Date: 28 January 2021

### **Application by London Resort Company Holdings for an Order Granting Development Consent for the London Resort**

#### **Advice following issue of decision to accept the application for examination**

Access, Rights of Way and Public Rights of Navigation Plans

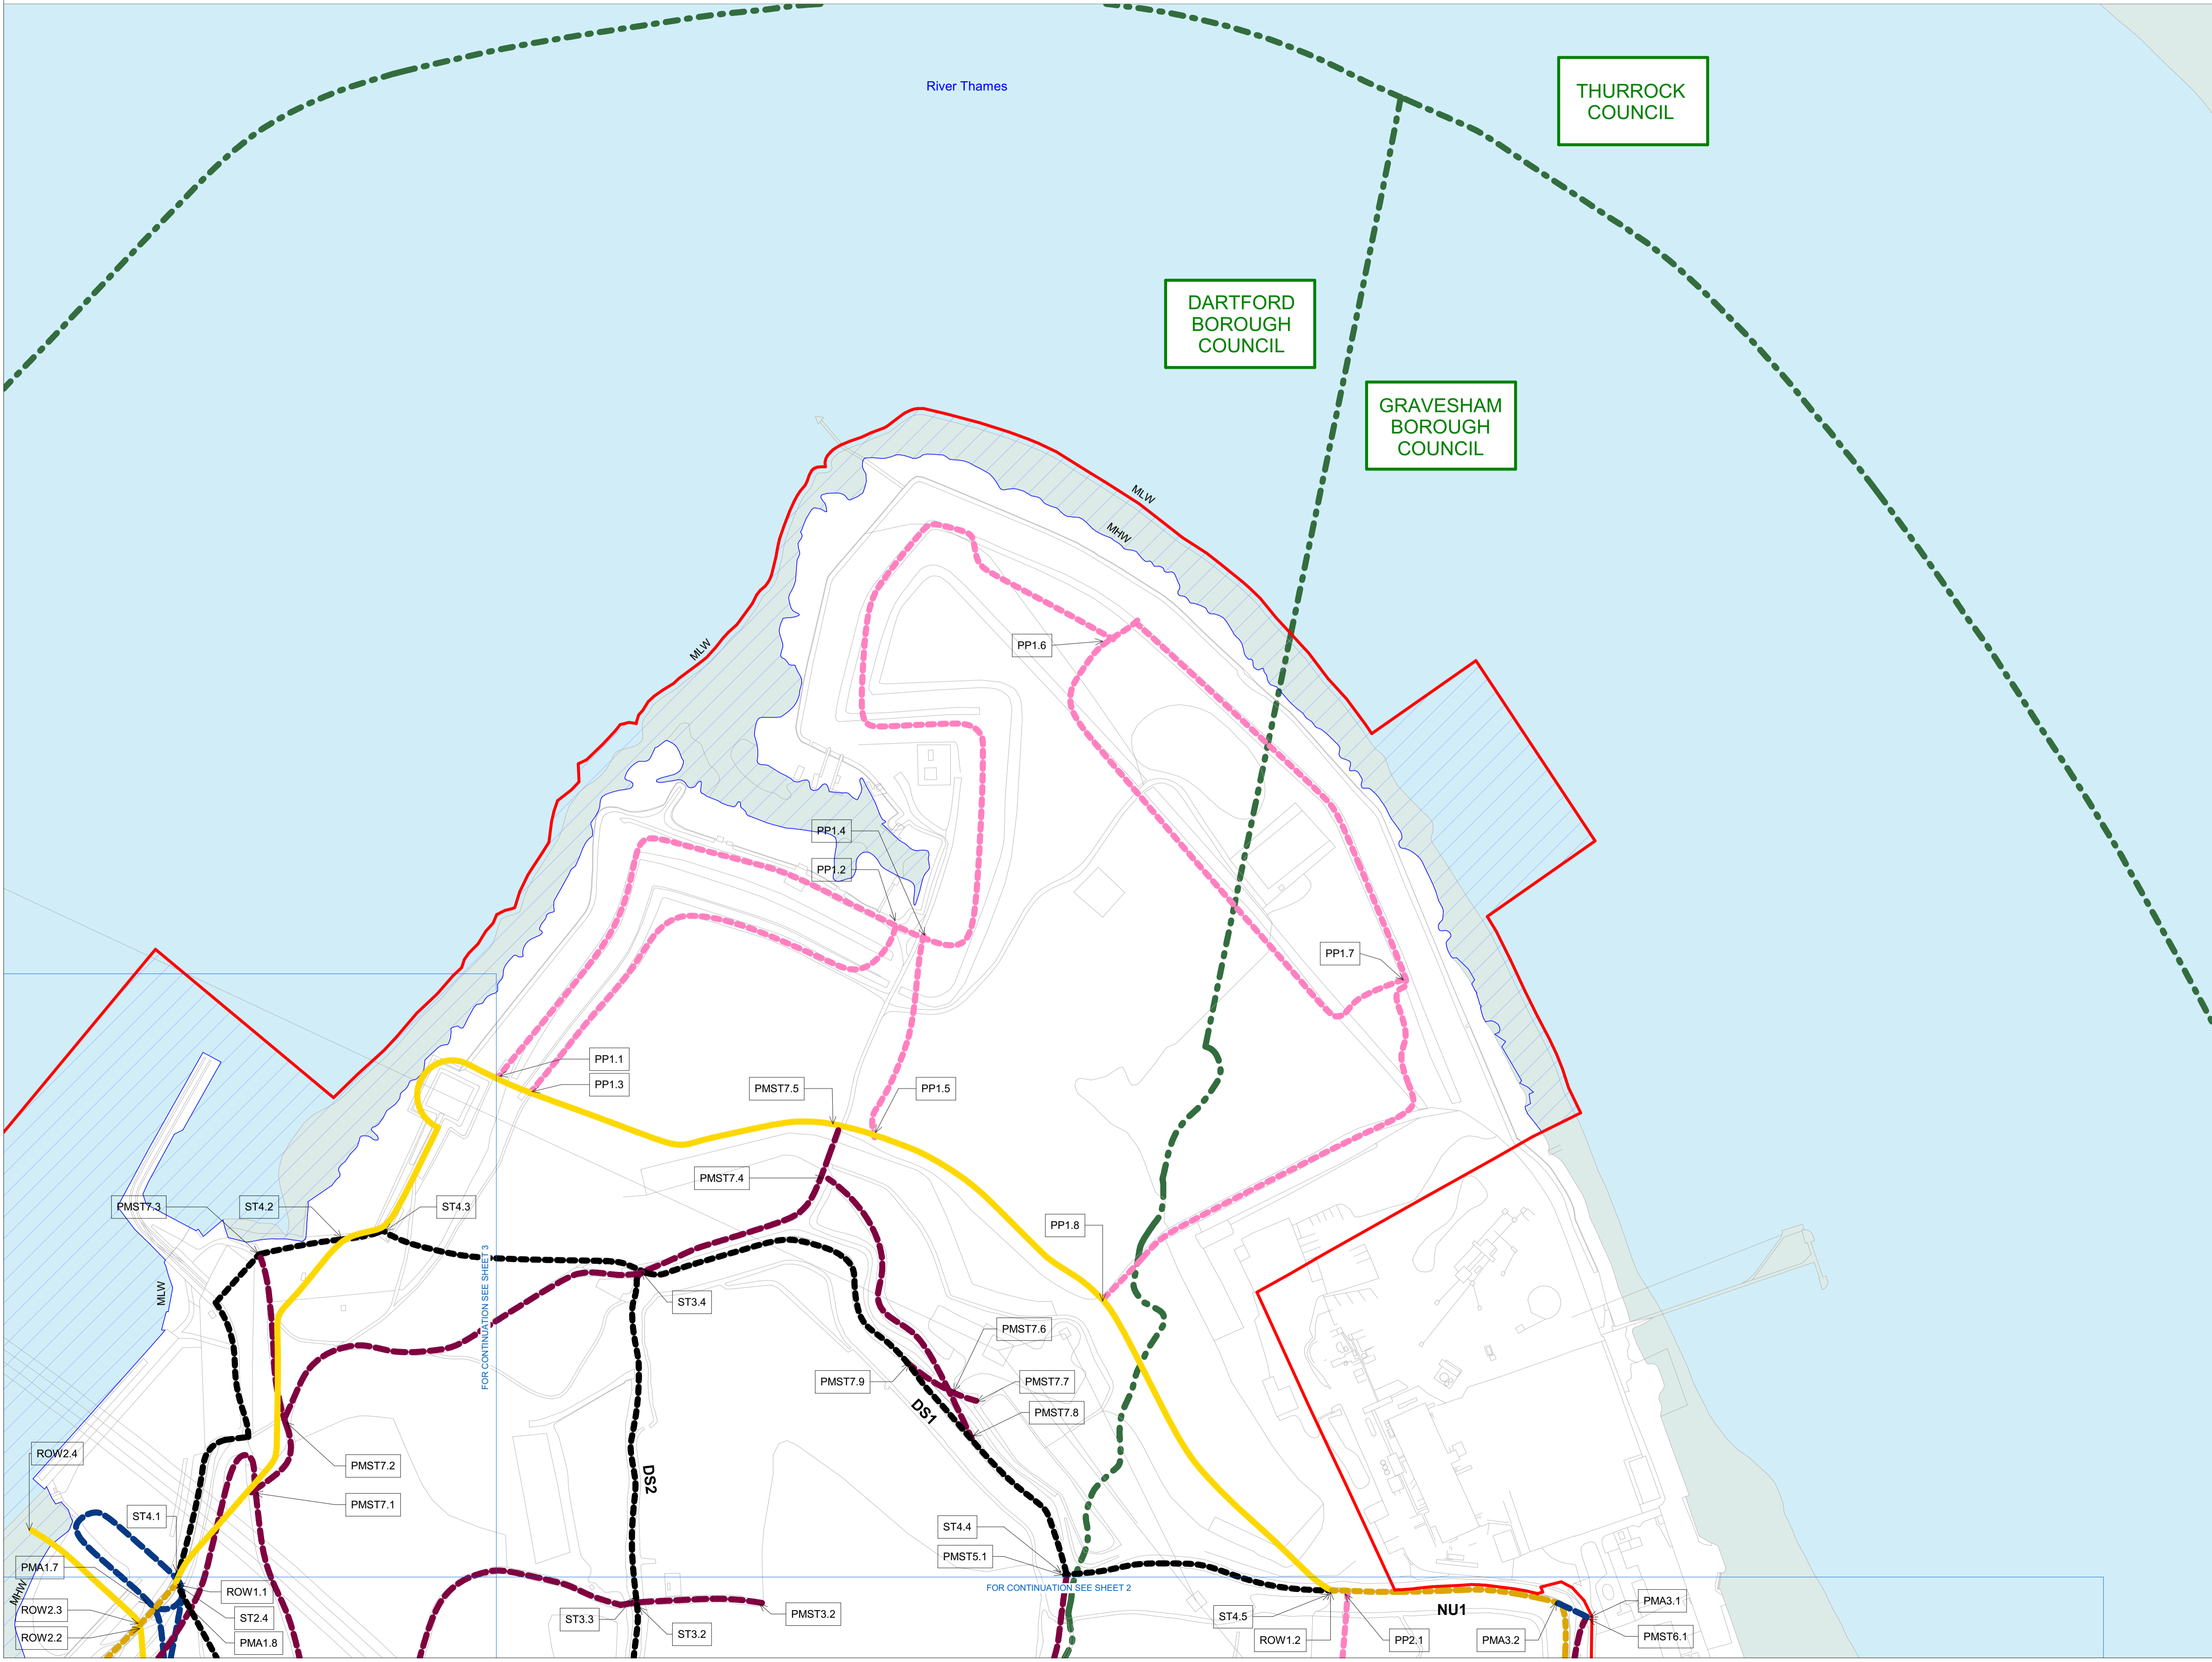
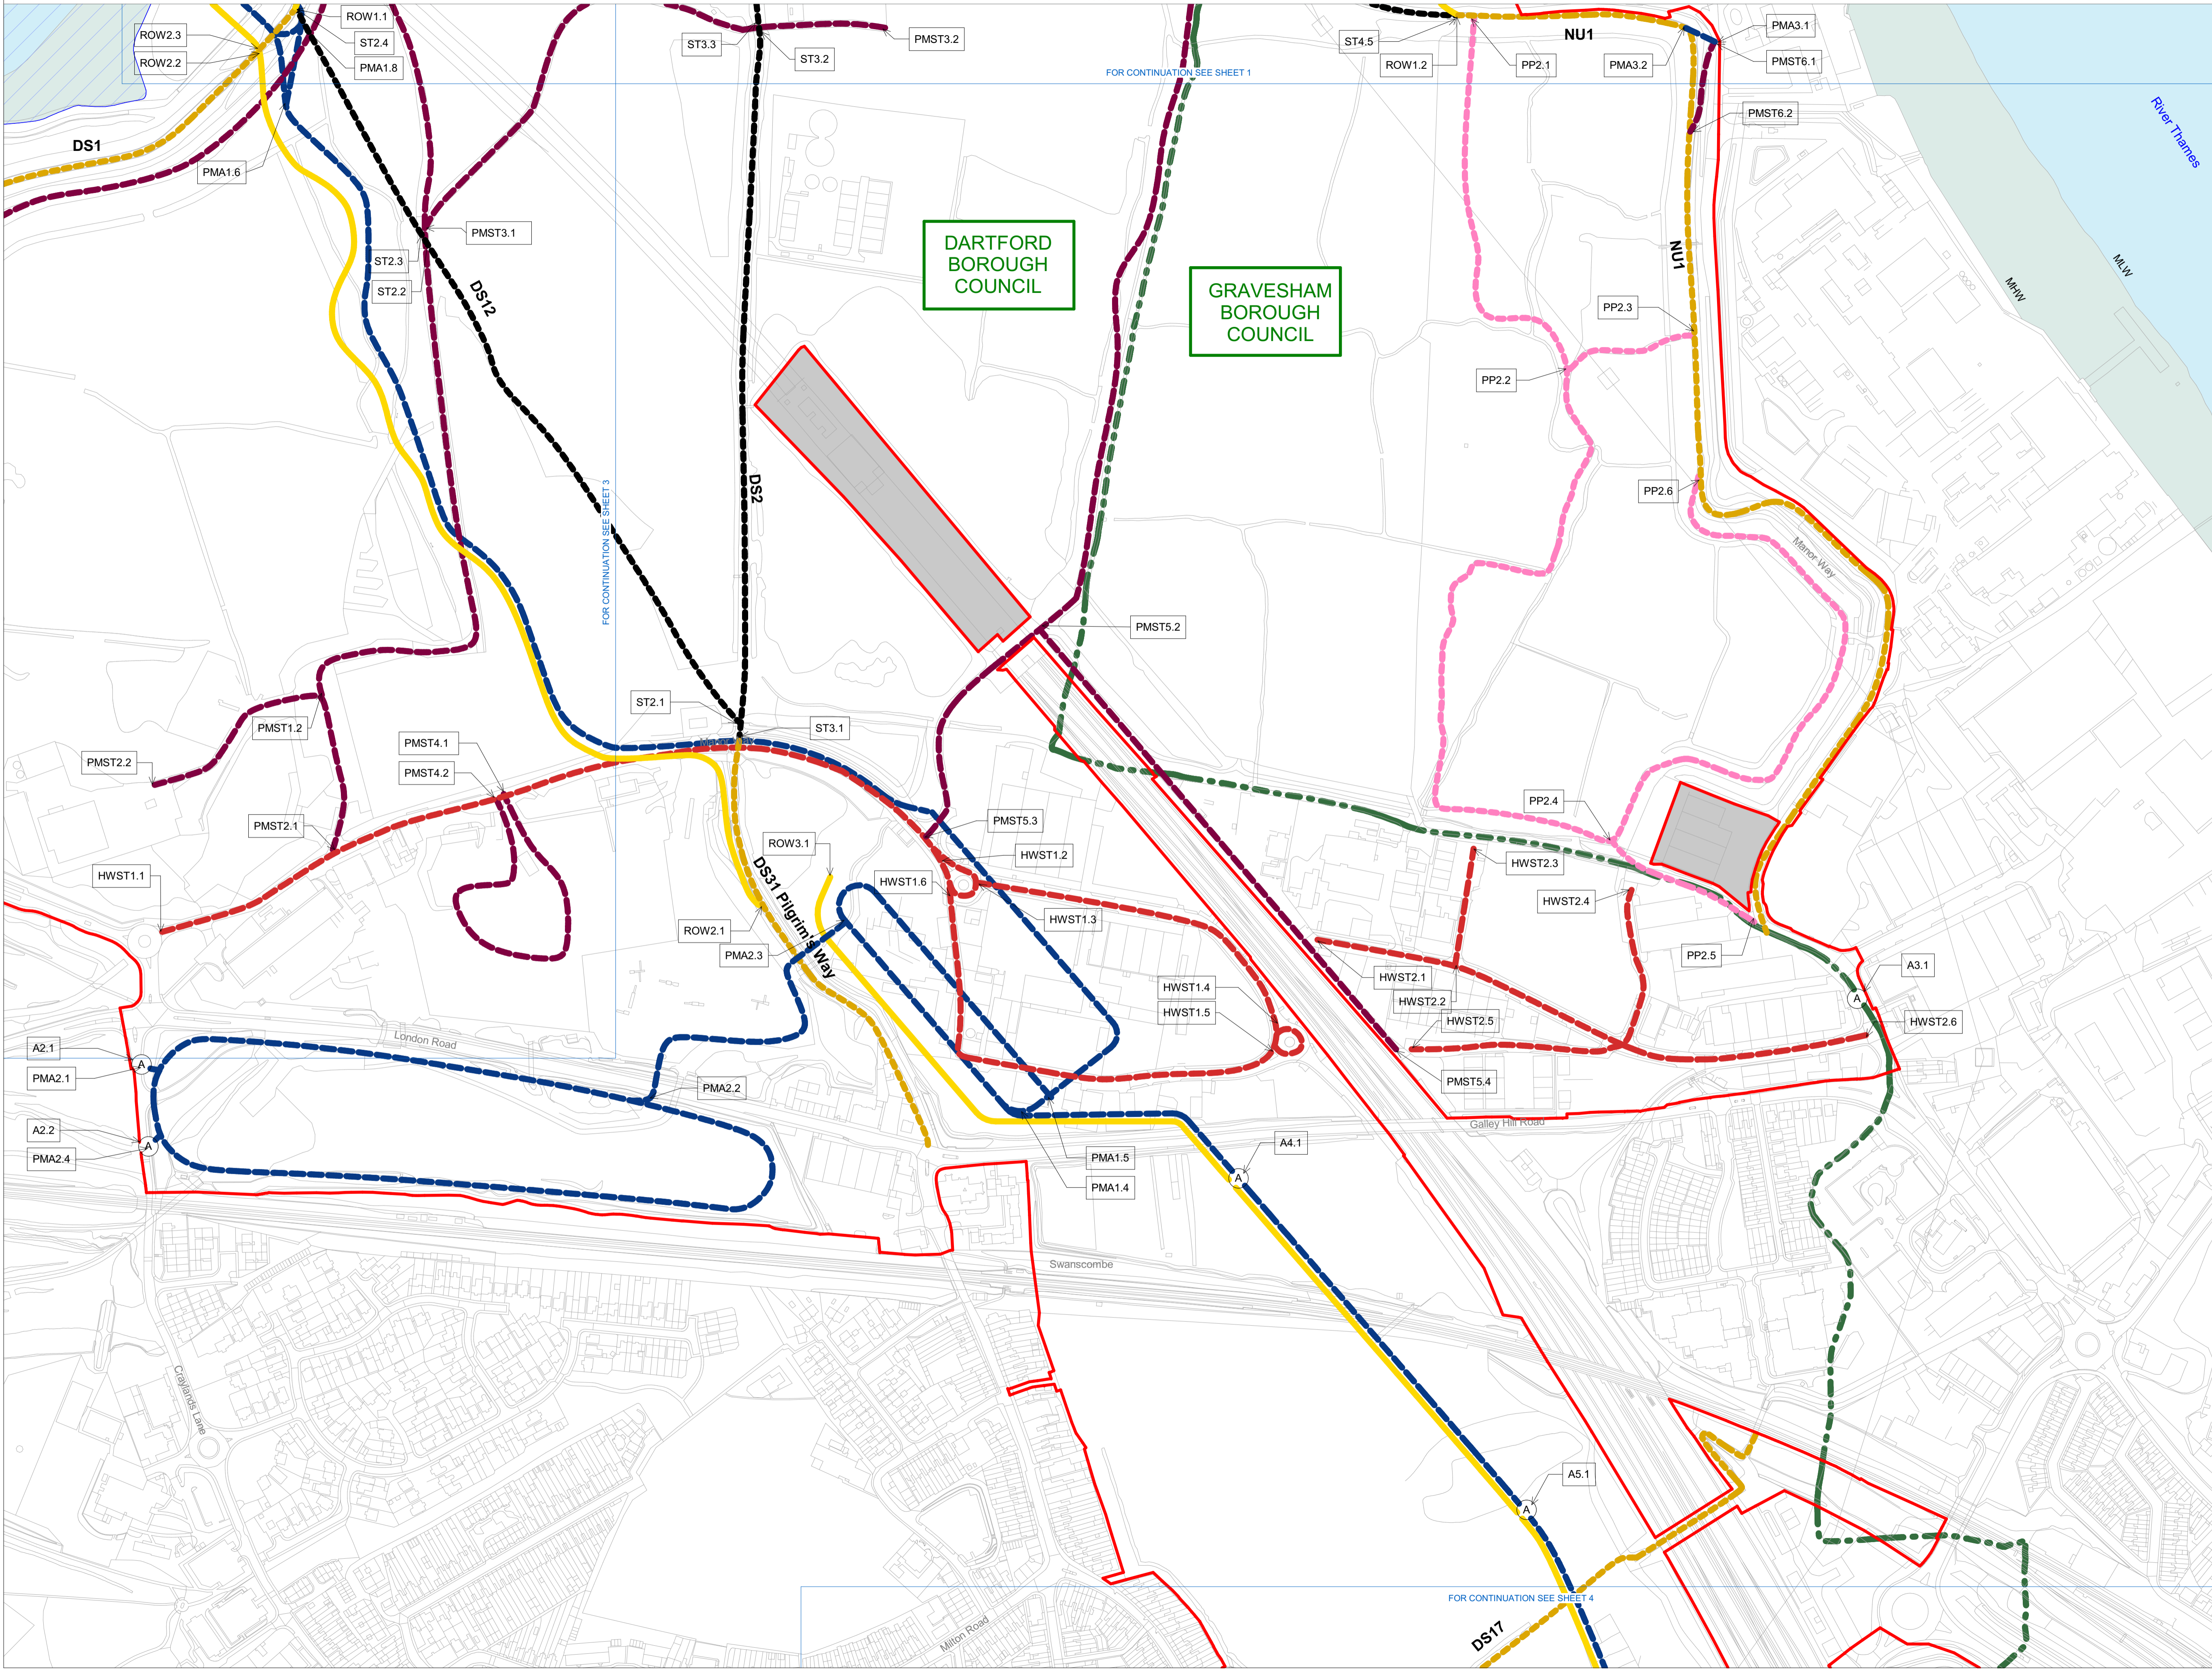
The Applicant is requested to provide updated plans which address the issues raised in Box 30 of the checklist
